From: Thomas Callaway
Sent: 12 May 2015 16:34
To: Planning.Responses
Subject: RE: Planning Consultation on: EG/24/15/HH

Engineers comments in respect to surface water drainage:

APPLICATION **EG/24/15/HH**
NO:

Site Address: Willow Cottage Church Lane Eastergate PO20 3UY

FLOOR PLAN

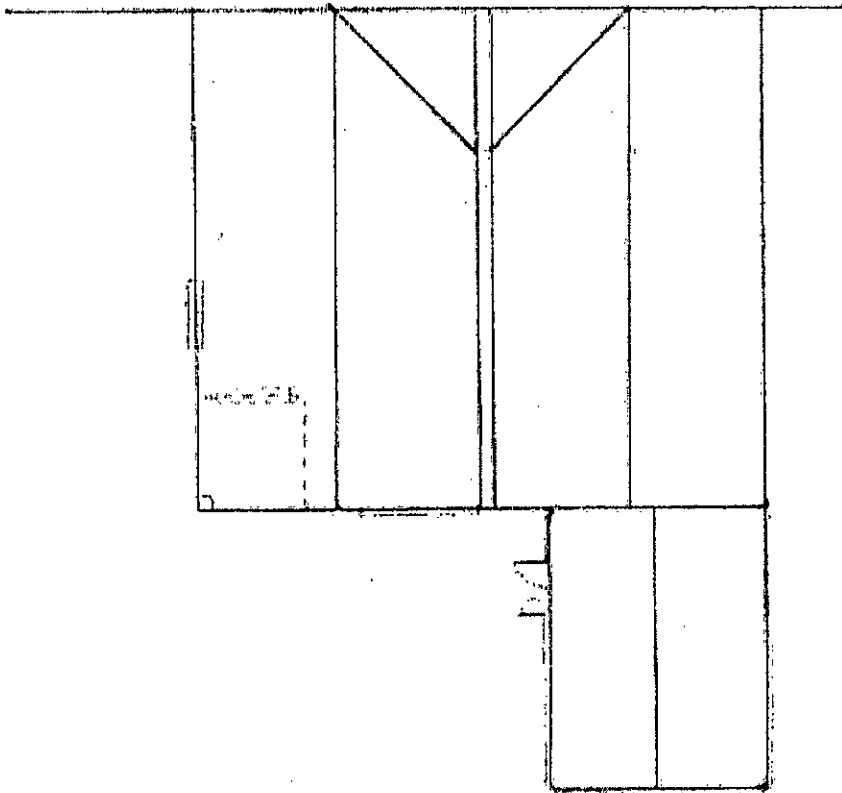
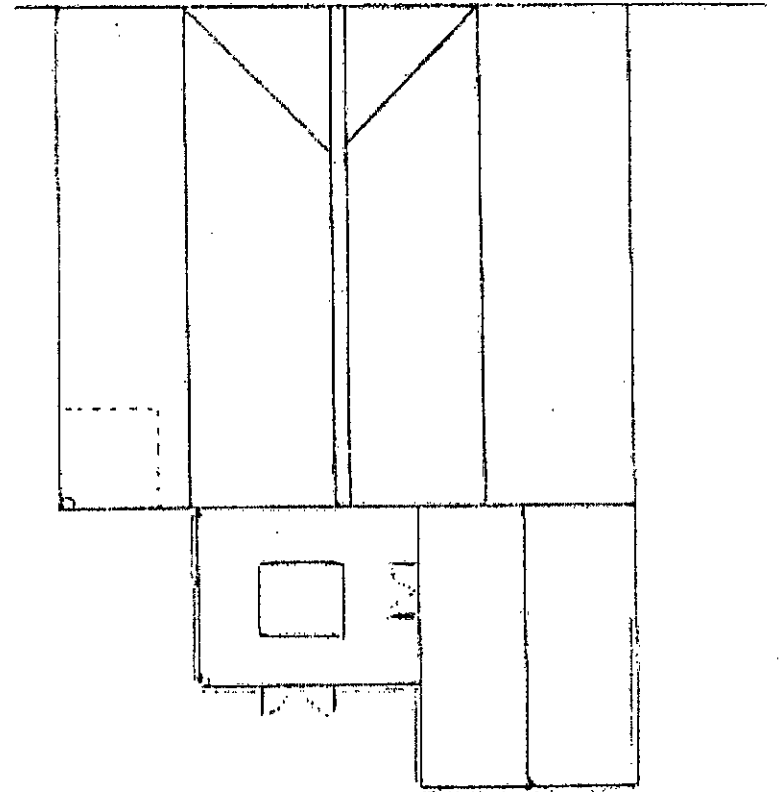
Infiltration must be considered for surface water from all new roof area.

Infiltration rates for soakage structures are to be based on percolation tests undertaken in the winter period and at the location and depth of the proposed structures. The percolation tests and design must be carried out in accordance with BRE 365, CIRIA R156 or a similar approved method and cater for the 1 in 10 year storm between the invert of the entry pipe to the soakaway, and the base of the structure. It must also have provision to ensure that there is capacity in the system to contain below ground level the 1 in 100 year event plus 30% on stored volumes, as an allowance for climate change. Adequate freeboard must be provided between the base of the soakaway structure and the highest recorded annual groundwater level identified in that location.
